20 November 2016

**APPLICATION NO SSD 16-7881 SYDNEY OPERA HOUSE TRUST
SYDNEY OPERA HOUSE FUNCTION CENTRE AND RELATED WORKS**

CONDITIONAL OBJECTION

Figure 16. Proposed new temporary Ballet Rehearsal Room Ground Floor Plan (Source: TZG)

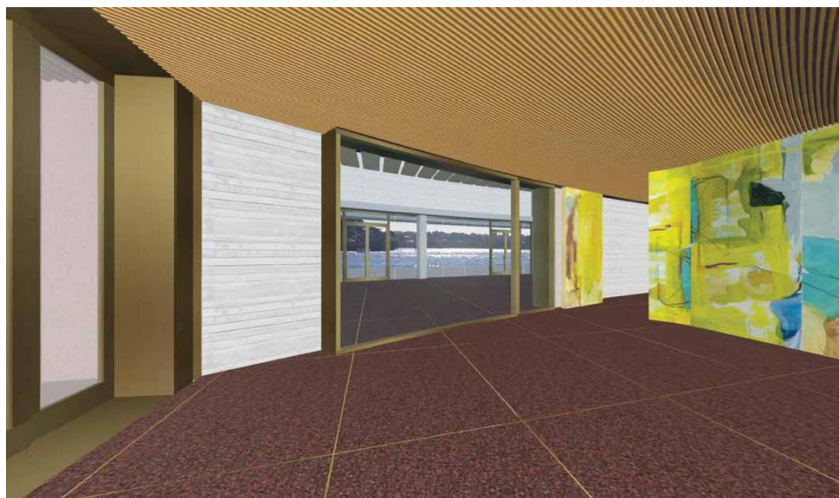
Dot point 5 proposes that the rehearsal room be relocated to the south-eastern side of the building – i.e., facing Farm Cove. This is stated to be “temporary”. The question might be asked: “how long is temporary?” and “what is the long-term resolution to meet the needs for rehearsals?”

Figure 20. Proposed treatment of the Northern Broad Walk with bollards and umbrellas (Source: TZG)

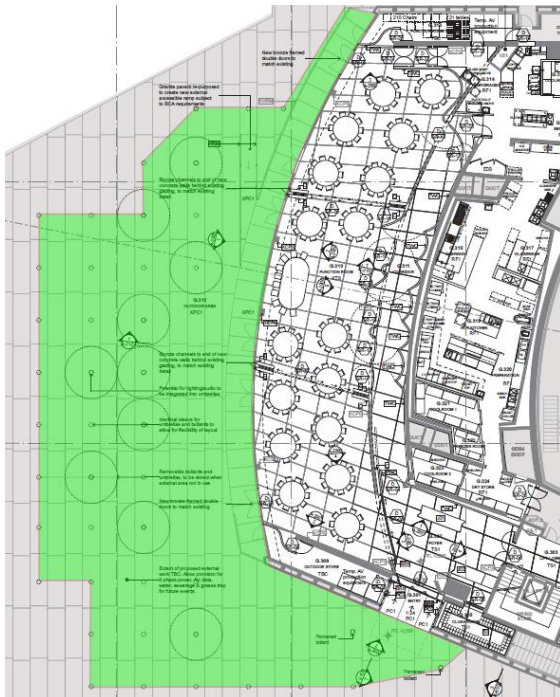
The feasibility of intrusion in future is indicated by the reference in description of the works (**dot point 3**) to “**removable bollards and umbrellas in the northern broadwalk** (that is, outside) **for function-related events**” (emphasis added). That seems to allow that obstructions will be removed so that function-related events can be held on the northern broadwalk – i.e. outside. What else can it mean?

However the proposal is to provide infrastructure not only for services inside but to cater for extension outside onto the northern (or southern, for that matter) concourse, and in that case, the anti-social problems are not remedied – and against that eventuality, this objection is lodged.
